Our ref: RA/2025/148651/01-L01
Your ref: 2025/92010

DISCHARGE OF CONDITION 5 OF THE DEEMED PLANNING PERMISSION GRANTED BY THE DEPARTMENT FOR TRANSPORT IN RELATION TO THE NETWORK RAIL HUDDERSFIELD TO WESTTOWN (DEWSBURY) IMPROVEMENTS ORDER 2022, STAGE 5 OF THE DEVELOPMENT RAILWAY LINE AND ASSOCIATED LAND BETWEEN HUDDERSFIELD AND WESTTOWN (DEWSBURY), WITHIN THE ORDER LIMITS OF THE NETWORK RAIL (HUDDERSFIELD TO WESTTOWN (DEWSBURY))

- Condition 5b(x): Environmental Design Plan (Land Contamination and Hydrogeology) – Stage 5 Appendix B - Piling Risk Assessment (OLE) Addendum – OLE foundations in Mirfield area (Document reference: 151667-TSA-00-TRU-REP-W-EN-001806, dated July 2025).

Figure 4-2- Geological cross section (with CHS pile length/locations)

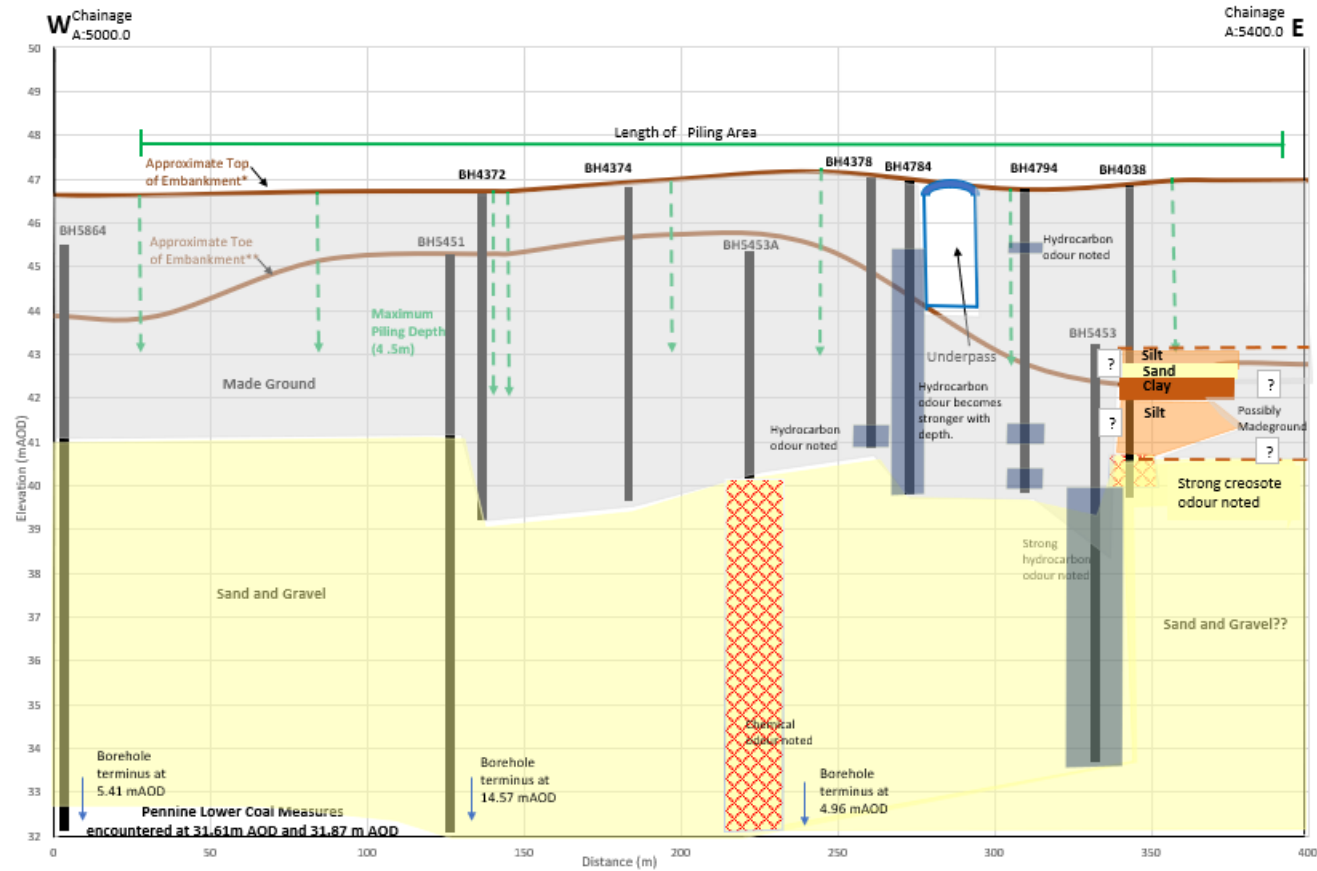
We also note in the conceptual model provided on "Figure 4-2- Geological cross section (with CHS pile length/locations)" that the pile installation appears to be restricted to the Ballast Made Ground.
